# CITY OF ALBUQUERQUE

**Re: JOURNAL CENTER – TRACT 5 – OFFICE BUILDING A**  
**7601 Jefferson Street NE**  
**Approval of Permanent Certificate of Occupancy (C.O.)**  
**Engineer's Stamp dated 09/02/2005 (D-17/D3)**  
**Certification dated 08/01/2006**

**Re: Journal Center Tract 5 – Office Building A, Corner of Masthead St and  
Tiburon St NE, Grading and Drainage Plan  
Engineer's Stamp dated 6-30-05 (D17-D3)**

Re: Drainage Plan for Journal Center, Tract 5, Building A, ZAP D-17  
Engineer's Stamp Dated July 29, 2005

C101

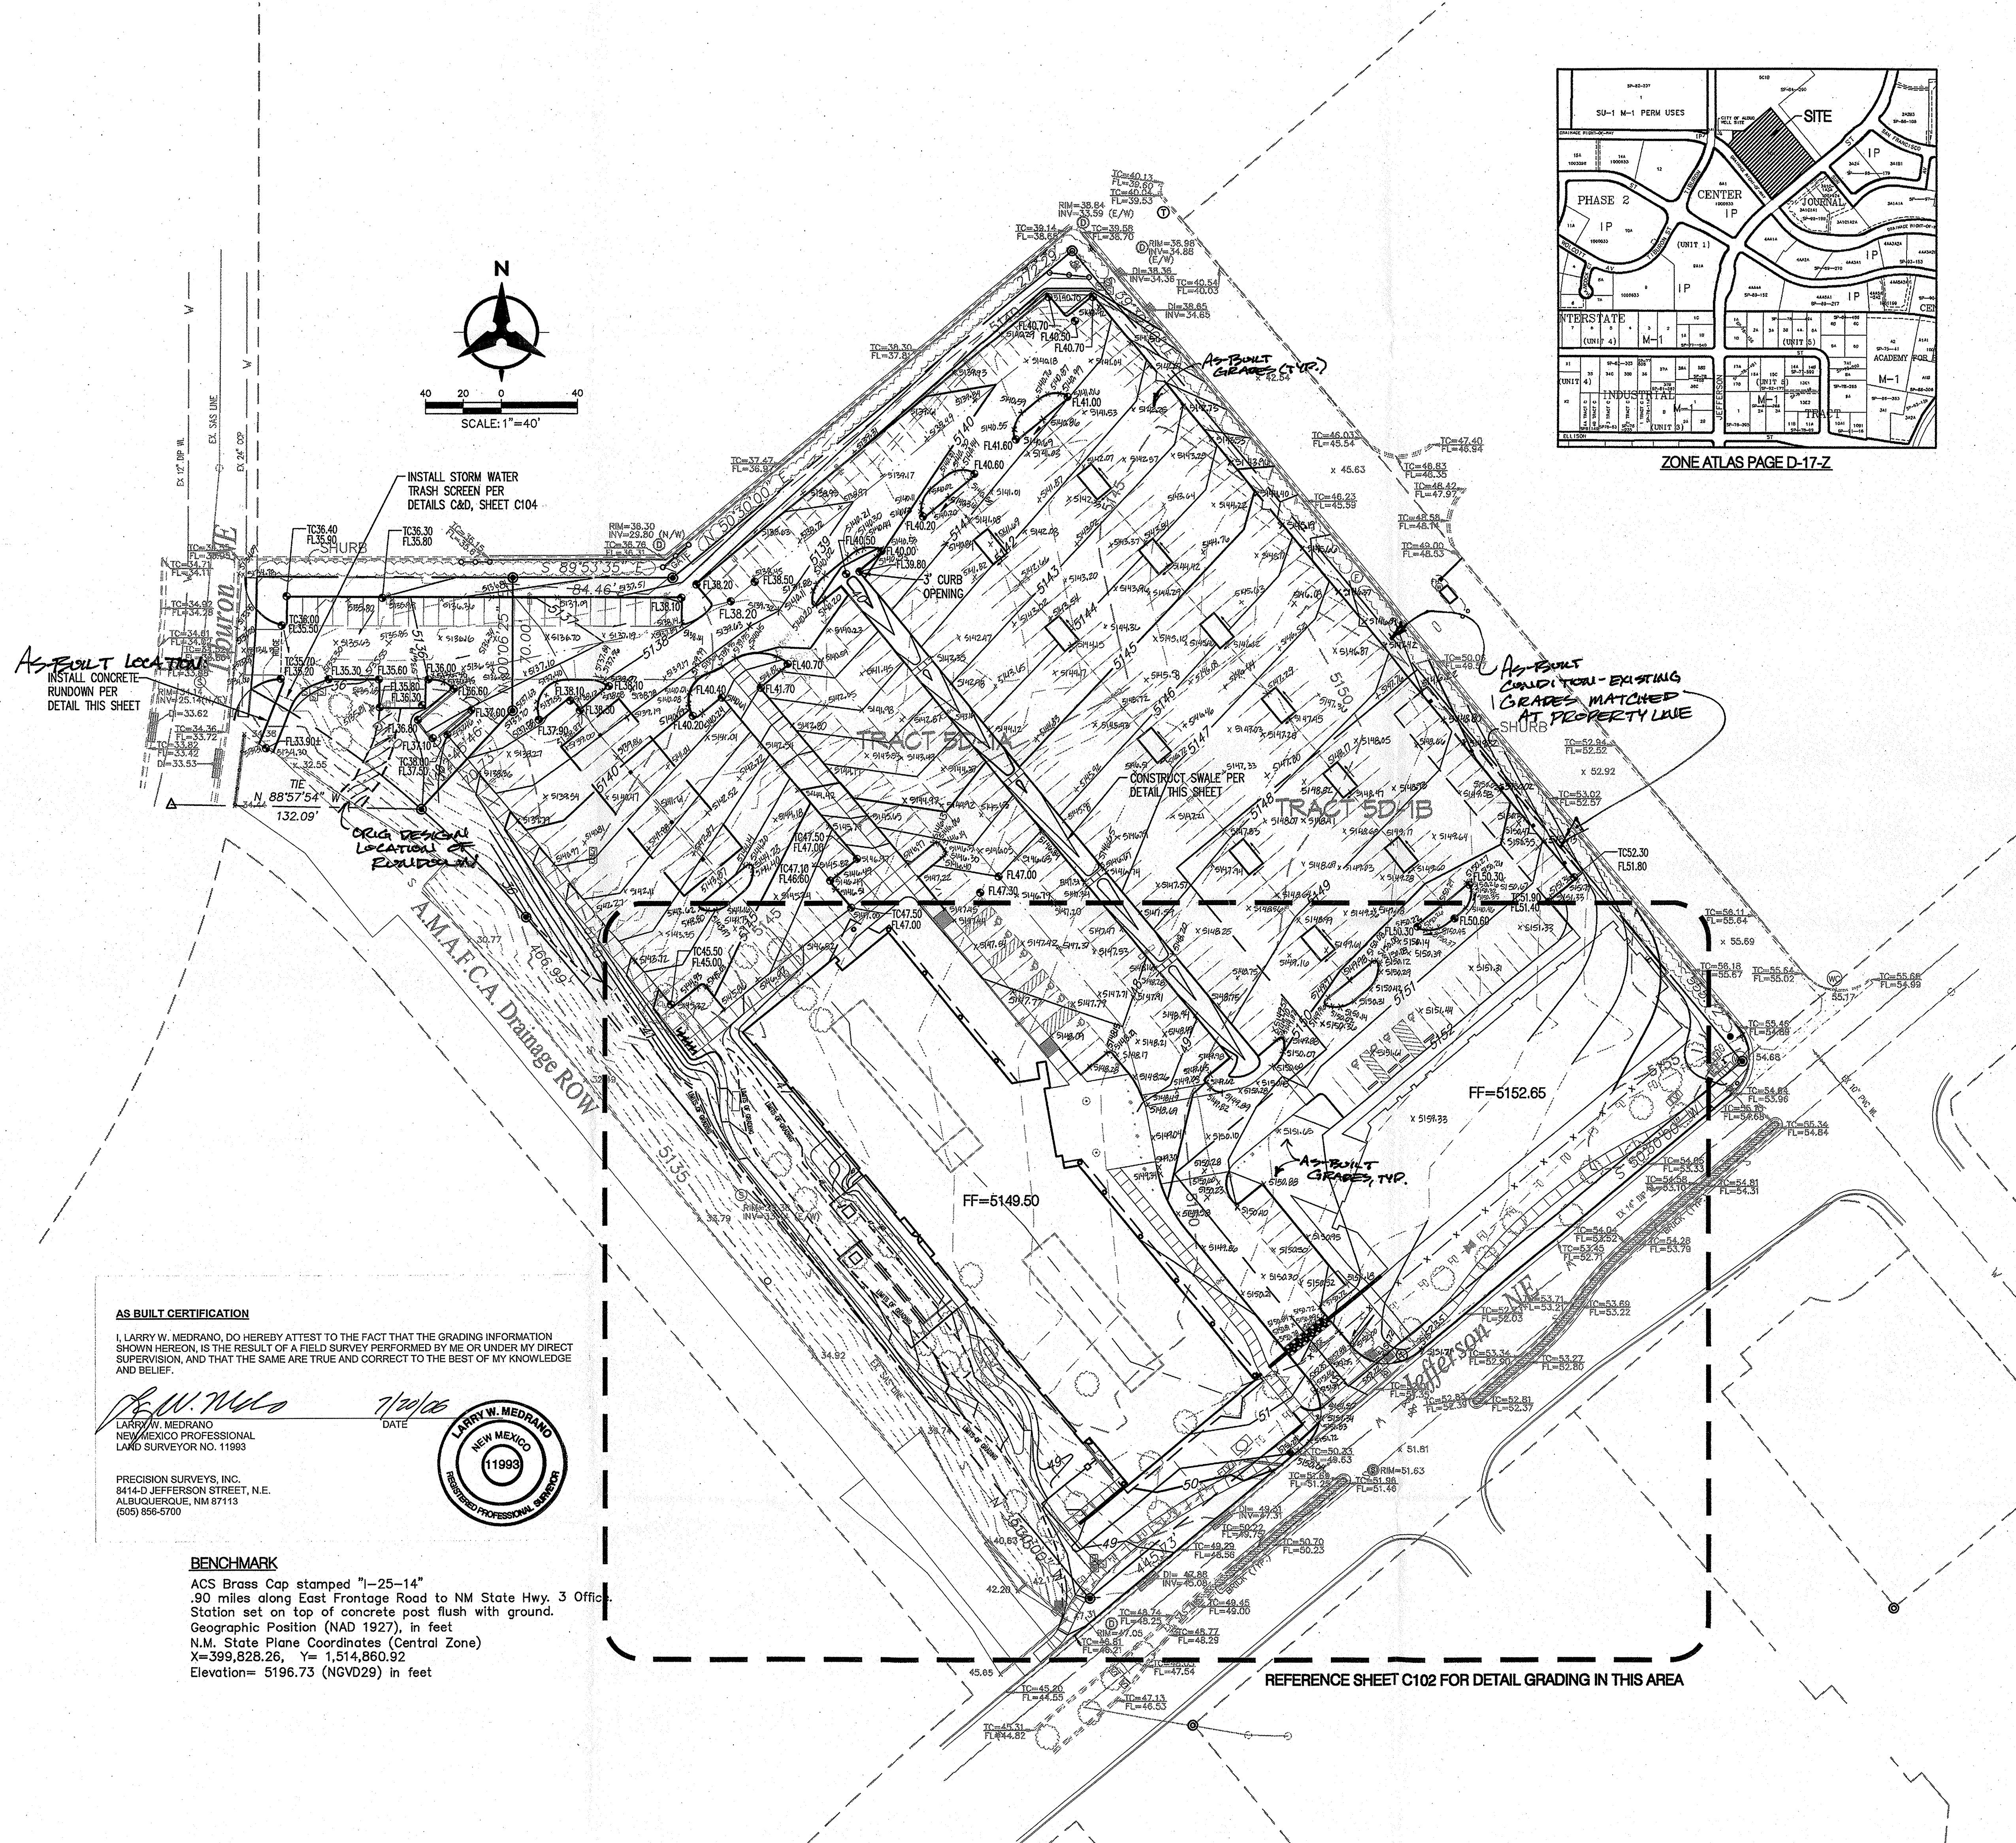
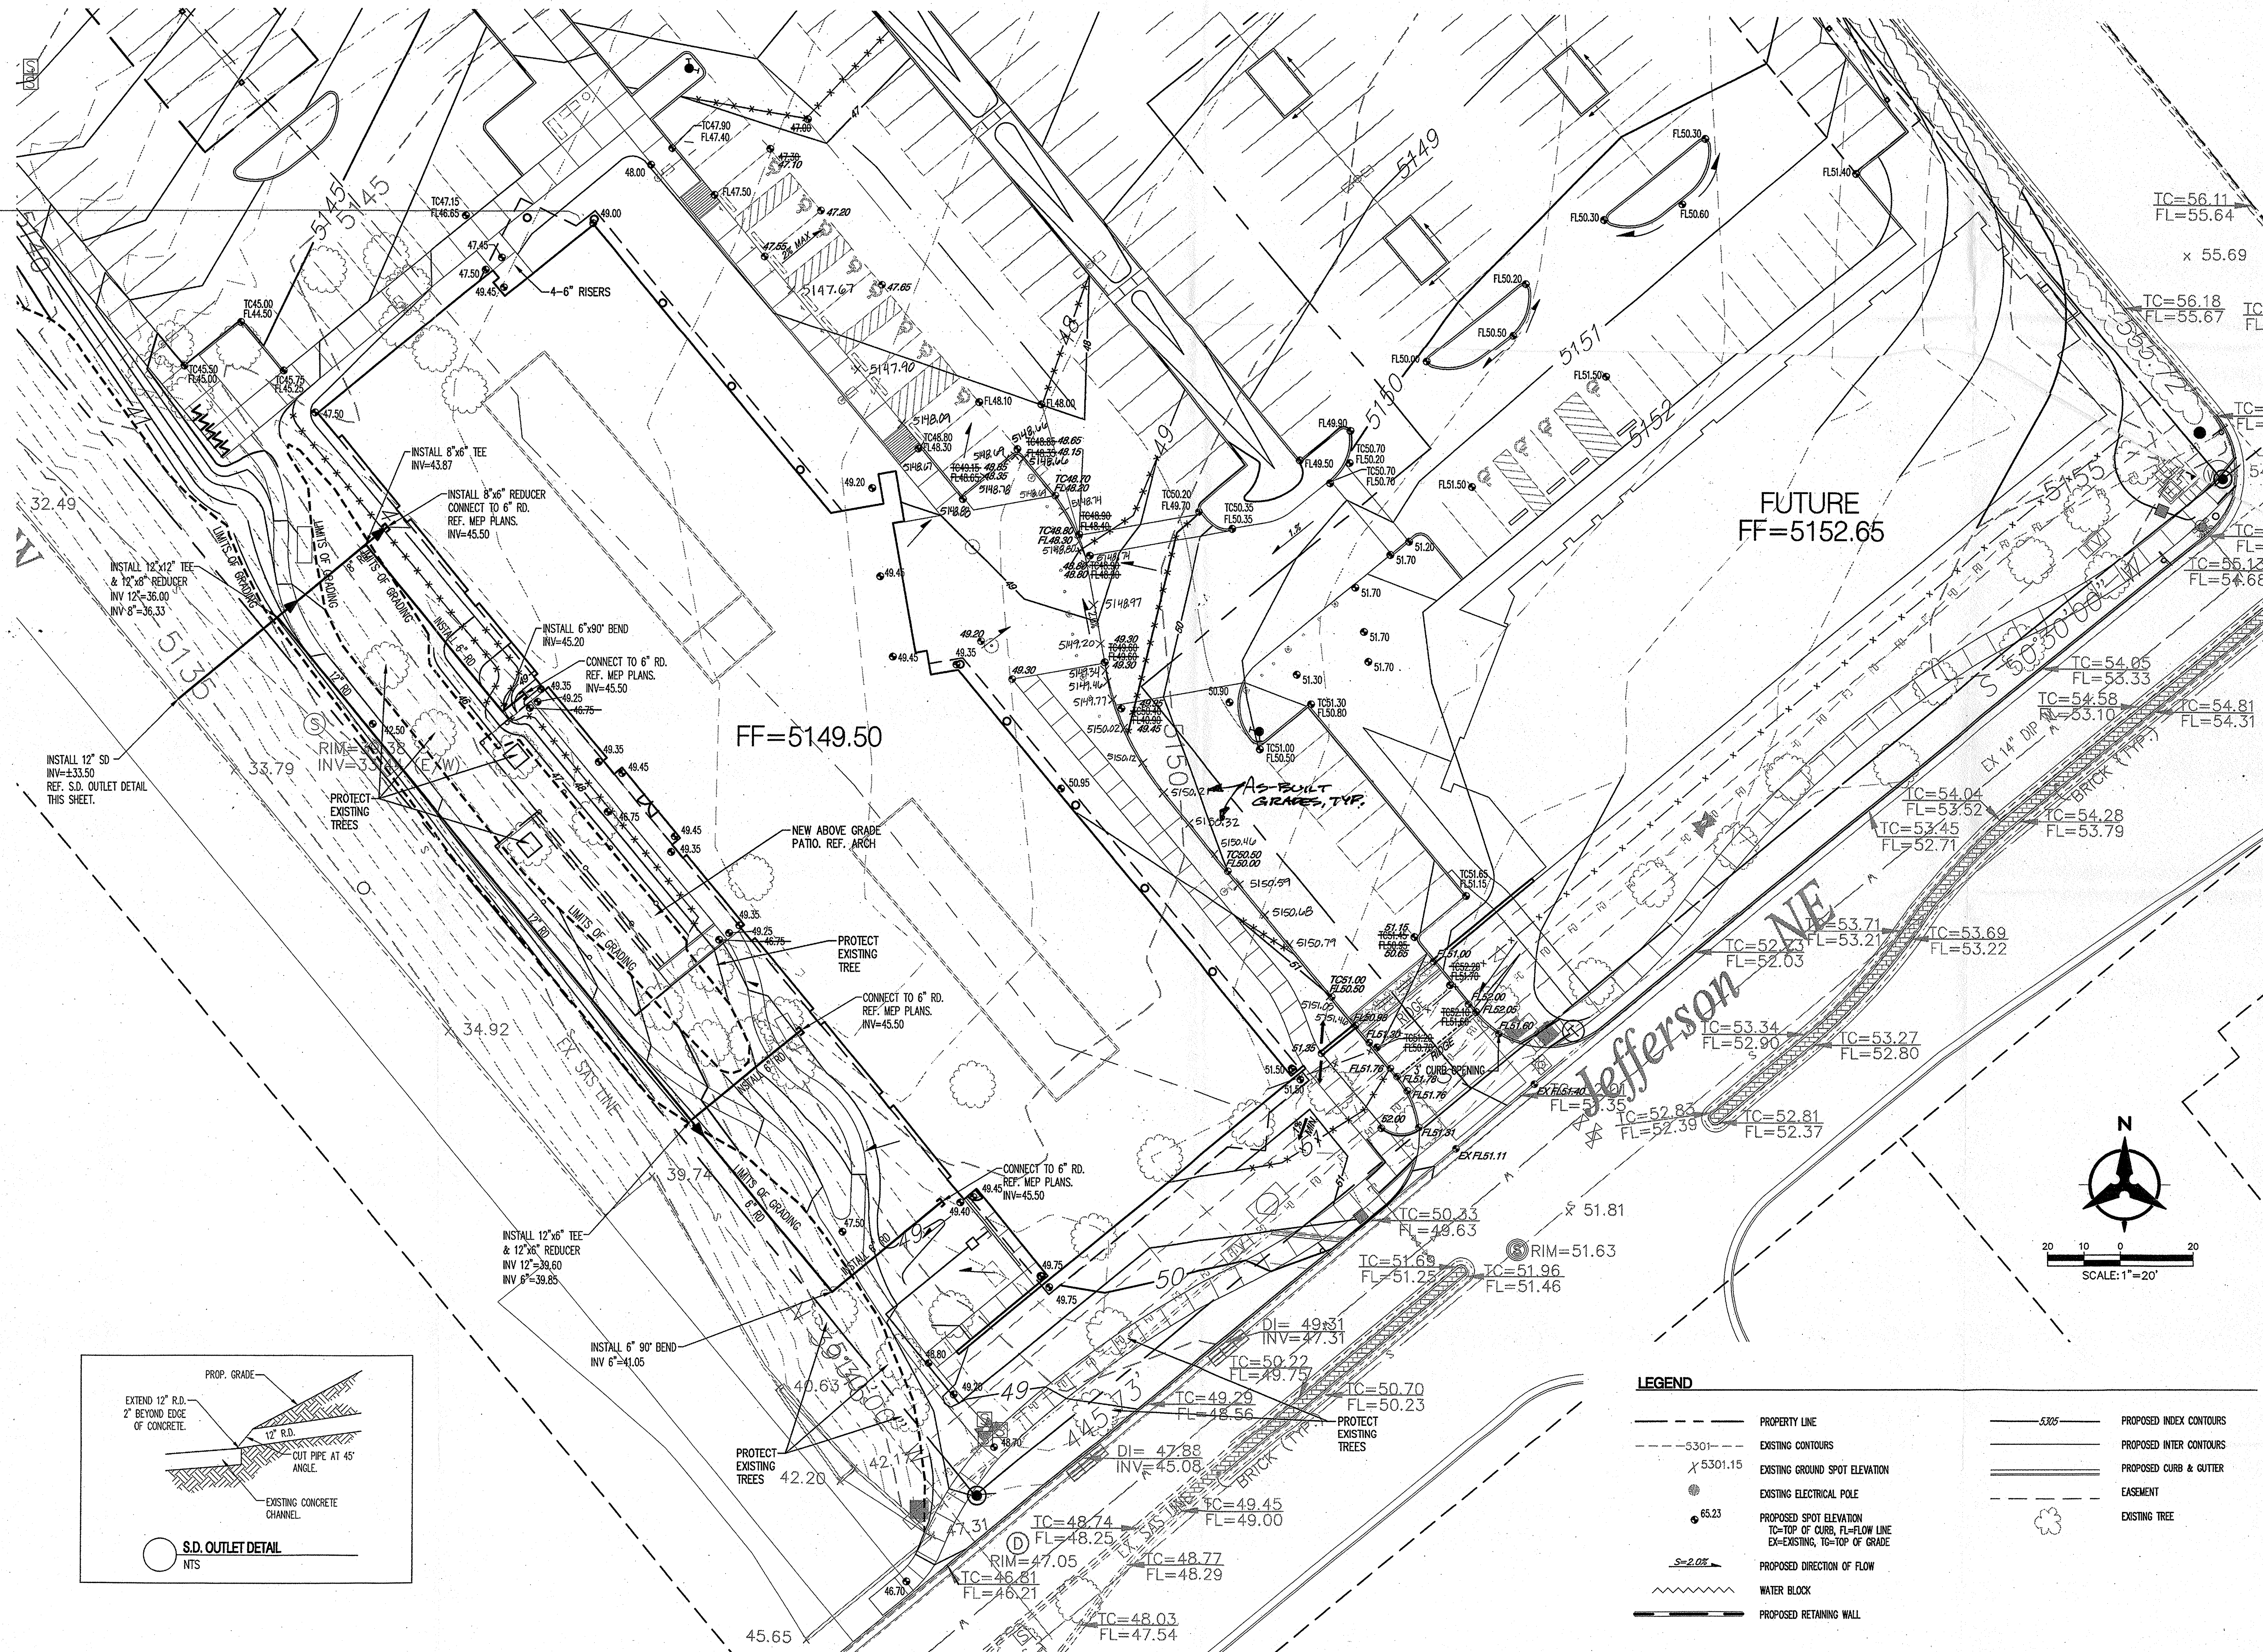
AMAFCA has reviewed the referenced plan with respect to the drainage outfalls to the North Pino Channel. The following comments should be addressed before release of Building Permit:

1. AMAFCA has an agreement with Journal Center Corporation for maintenance of the concrete portion of the channel only. Discharge of the roof drains down the grassy slope that is maintained by the management company must be approved by them. AMAFCA recommends connecting the roof drains so that there is only one discharge pipe that would outfall to the lip of the channel or down a concrete swale. The swale would have to be traversable by a mower.
2. Provide detail of the trash screen referenced on Sheet C101.
